## Appeal Decision

**Appeal Ref: APP/R5510/D/24/3341723**

**Hunters Moon, 34 Potter Street, Northwood, Middlesex HA6 1QE**

Drawing Title
PROPOSED OUTBUILDING
AND LANDSCAPING
DETAILS

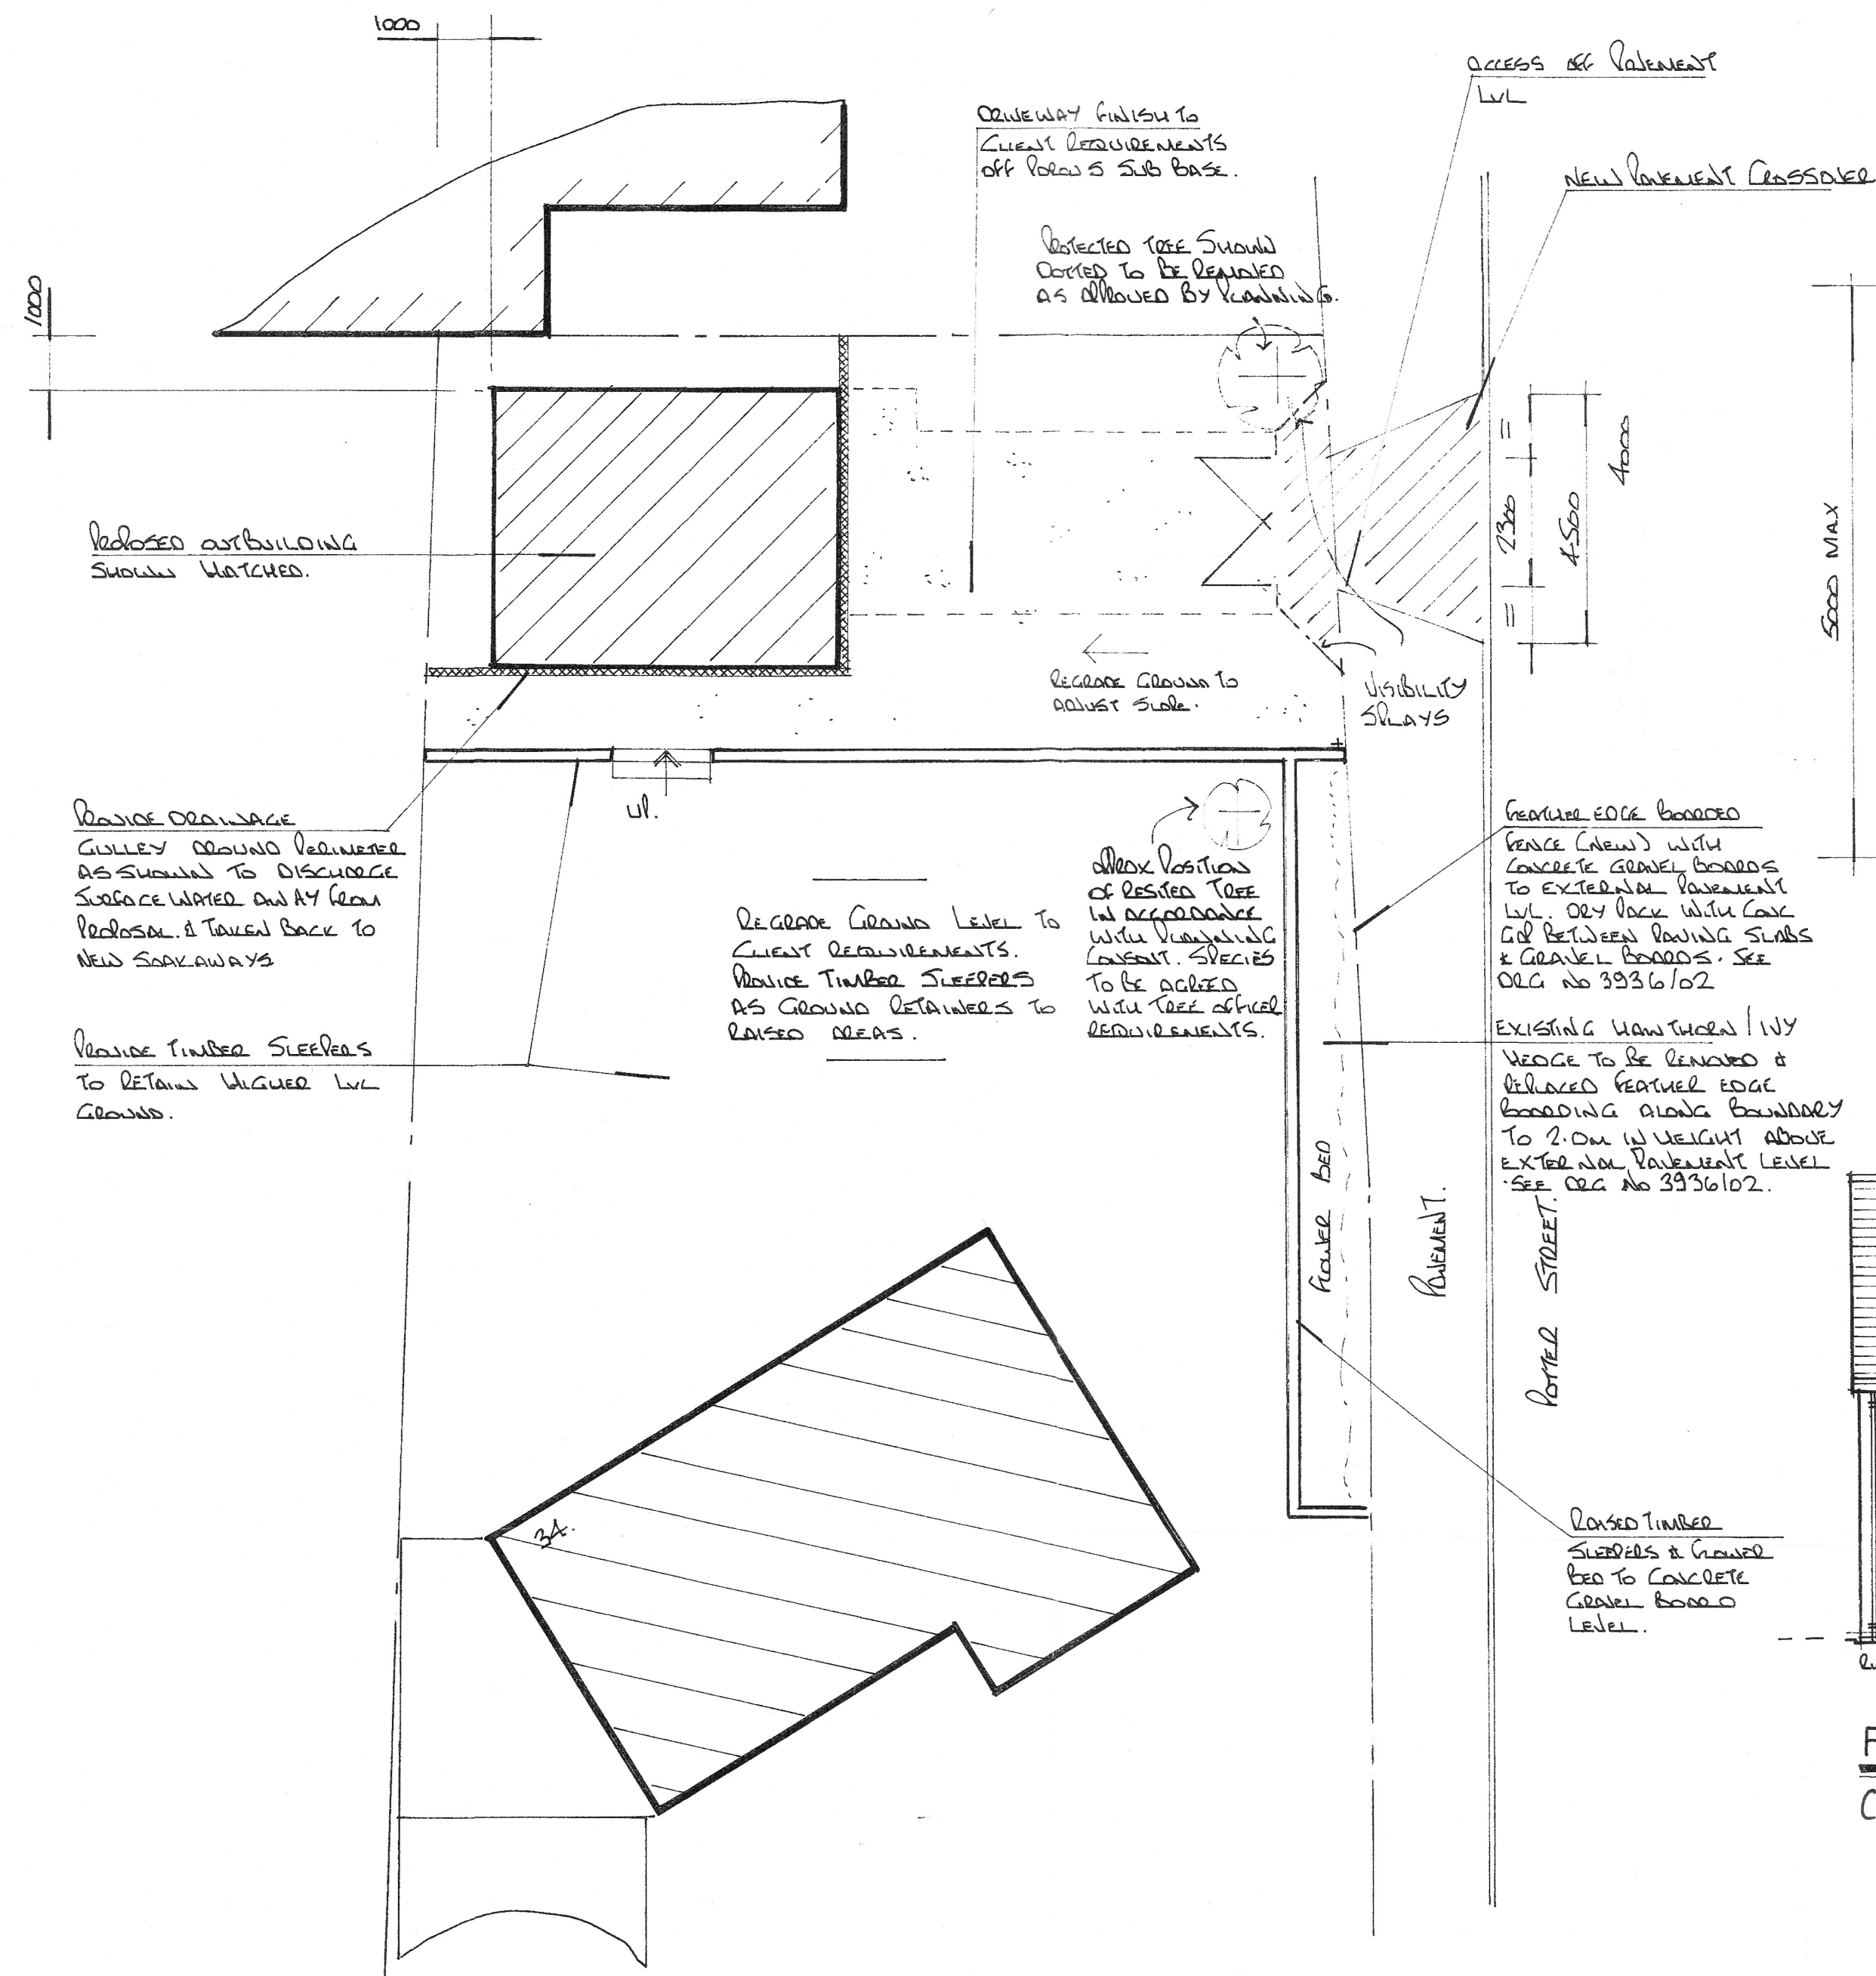
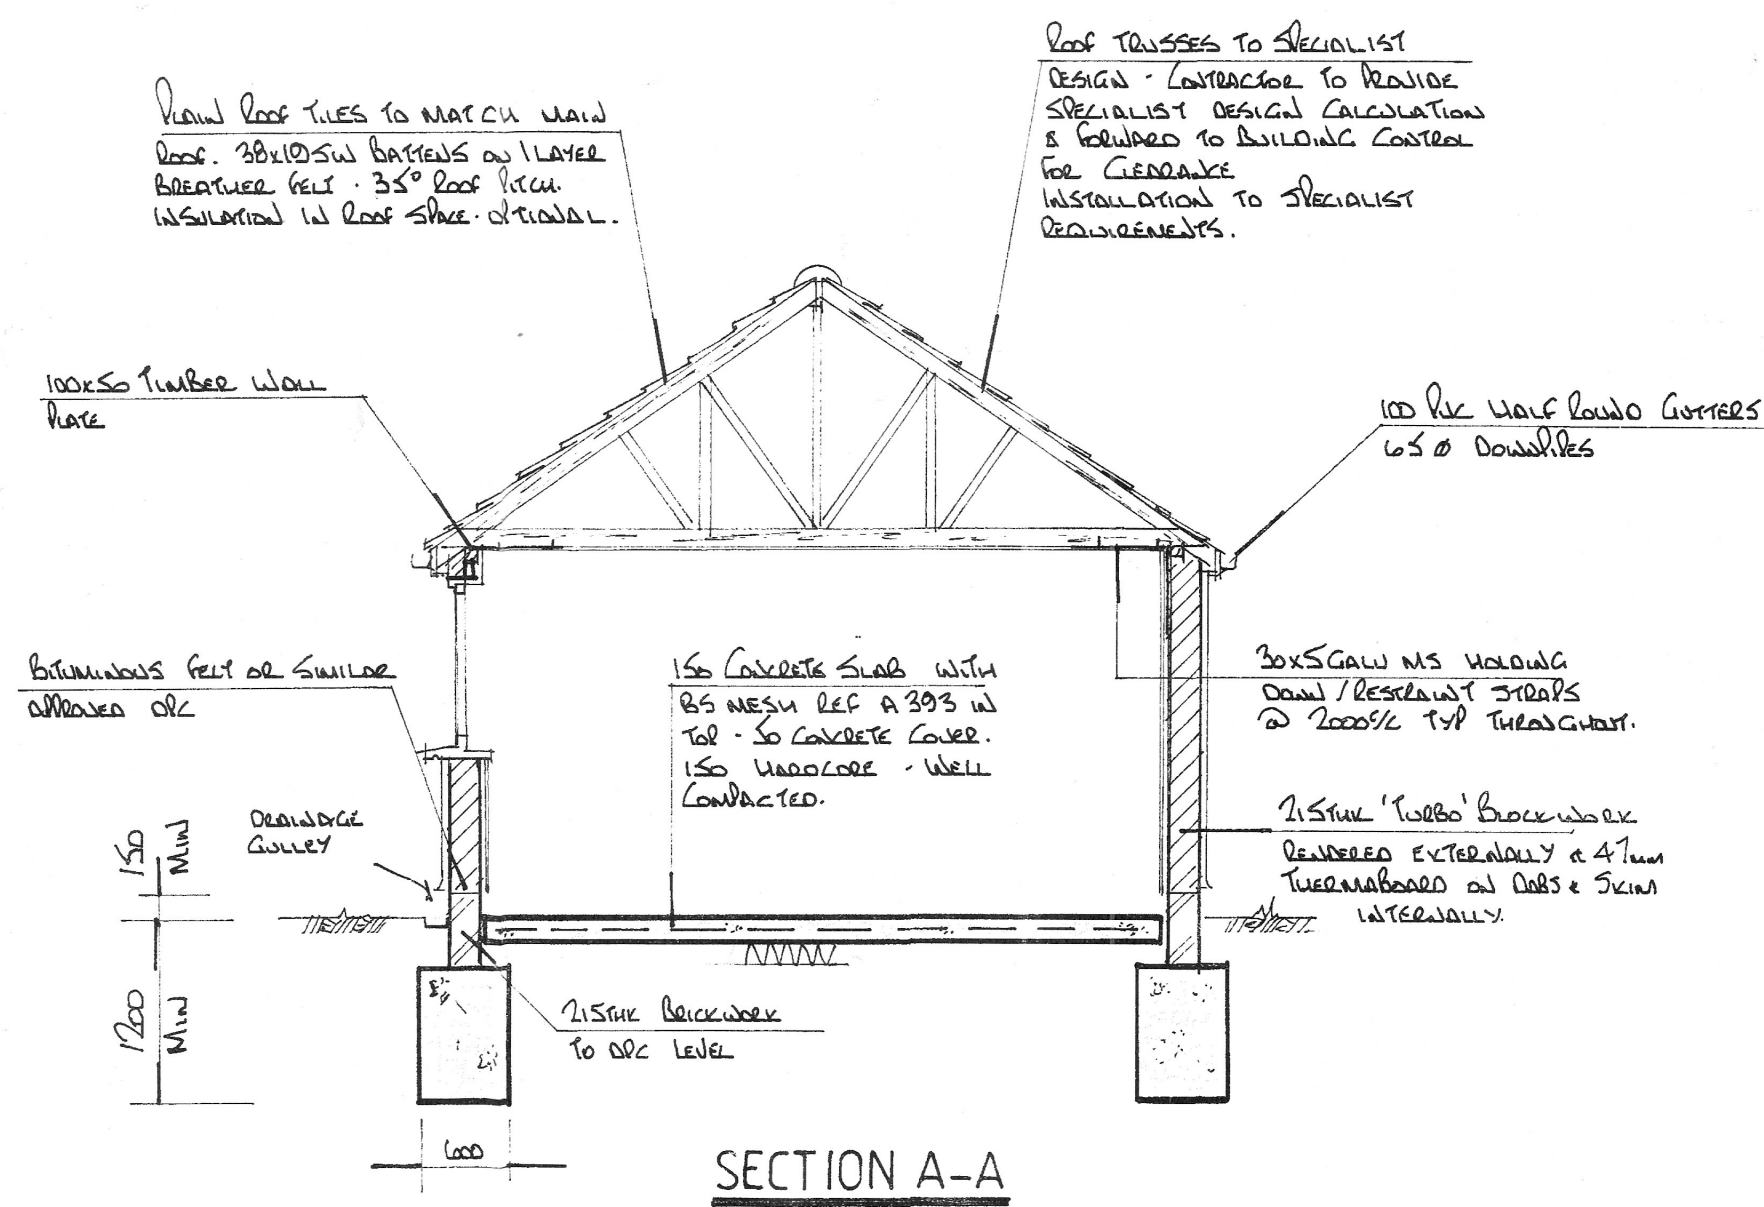
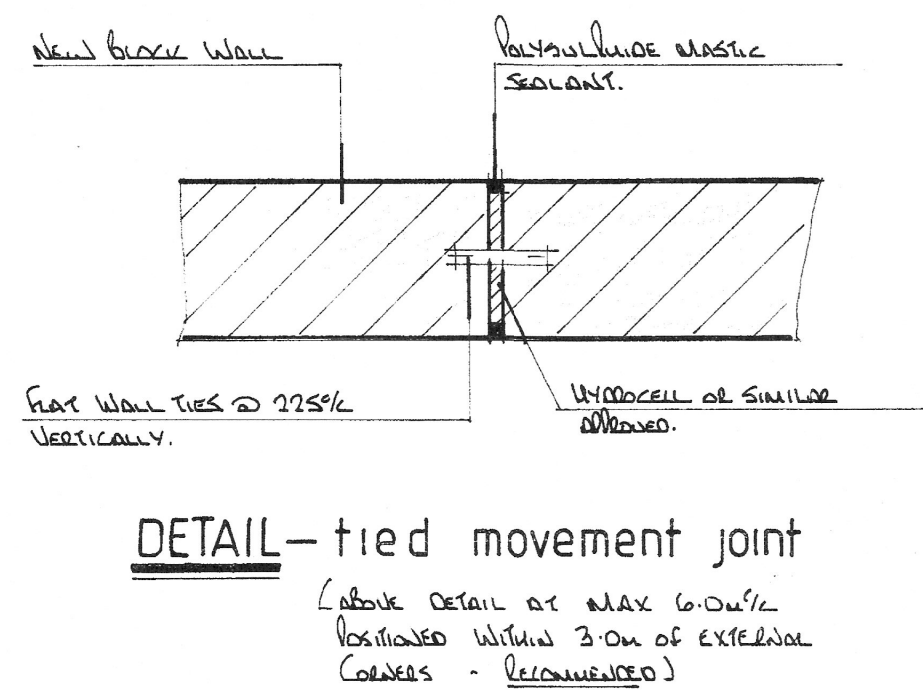
4. The proposed galvanised steel mast would be positioned at the front of a single storey garage, in line with the neighbouring property. Given the 10 metre height of the mast, it would be significantly taller than the garage that it would be viewed against when at full height and taller than the ridgelines of the neighbouring properties.

5. Although set back from the highway, the positioning and height of the mast with the antenna array, would make it an unduly prominent and highly conspicuous feature in views from both the public and private realm, particularly when approaching Potter Street from the southwest. While I note it would not exceed the total overall height of surrounding ridgelines in combination with any antennas on those properties, the proposal visually has a different appearance. It would be noticeably at odds with and fail to

7. I note that the antenna would be telescopic and would be 5 metres tall when retracted. However, limited information has been submitted as to how frequently it would be retracted. From the submitted information, it appears that this would only be in inclement weather. In any case, I am not satisfied that there would be any enforceable mechanism to ensure its retraction when not in use. Therefore, based on the information before me, I attached limited weight to the telescopic nature of the mast.
